City of Albuquerque Stormwater Construction Site Inspection Report

ESC File No.	H19E090	Project Name:	US Eagle FCU Menaul Branch			
NPDES Id. No.	NMR1003M3/NMR1003MO	Location:	7201 Menaul Blvd. NE			
6/3/2021	Owner		Contractor			
Operator	US Eagle FCU		Enterprise Builders			
Contact name & title	Michael Moore		Ralph Baldwin			
e-mail	mmoore@useagle.org		rpb@ebnm.com			
Contact Phone #	505-342-8888		505-857-0050			
COA Inspector	Thomas Evans		Start/End Time:	3:15 PM-3:25 PM		
Construction Phase:	infrastructure					
Type of Inspection:	Regular	Storm Event	Past Storm Event >0.25"	311/Complaint	Follow Up	
Weather at time of inspection?	clear		Temperature: ~	88		
Estimated date of last storm 0.25" or greater	5/31/2021

ESC-1

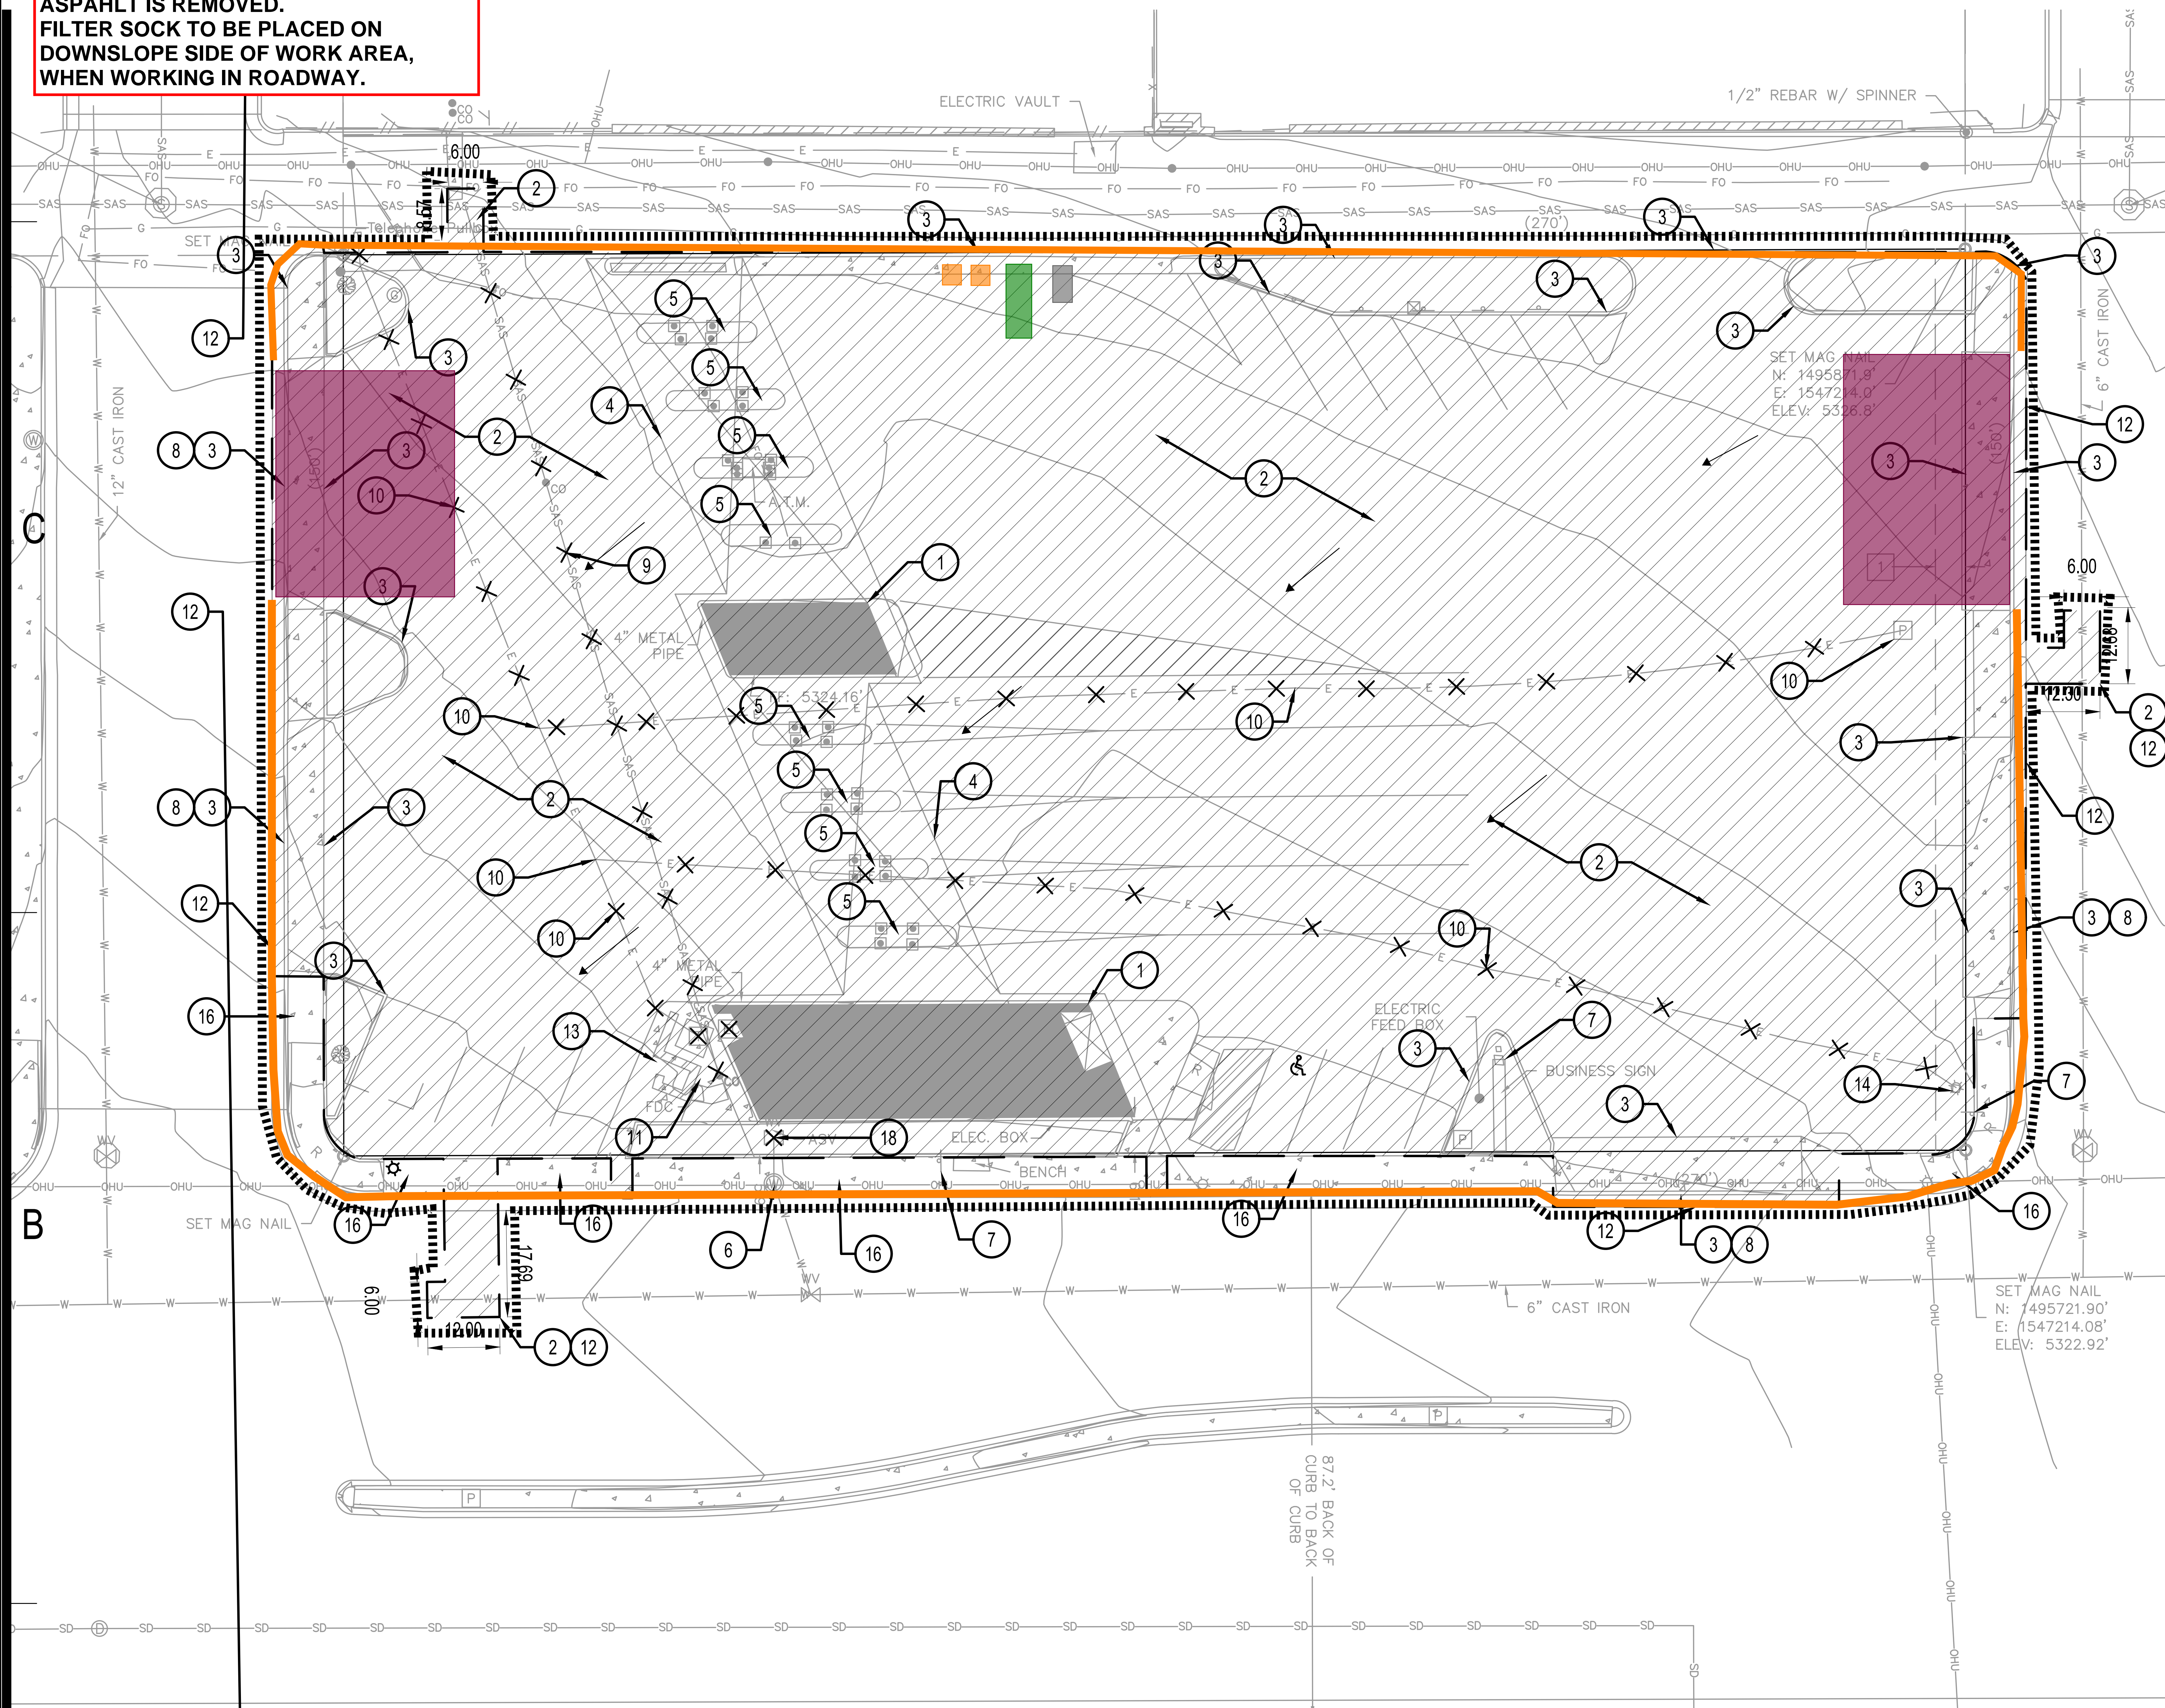
Item Number	Deficiency/ Corrective Action					
1	Sediment on sidewalk. Reposition mulch socks to prevent sediment from exiting the site. Sweep track-out and sediment daily.					
2	Wind screen missing in some sections. Install wind screen across all sections of the perimeter fence as shown in the ESC Plan.
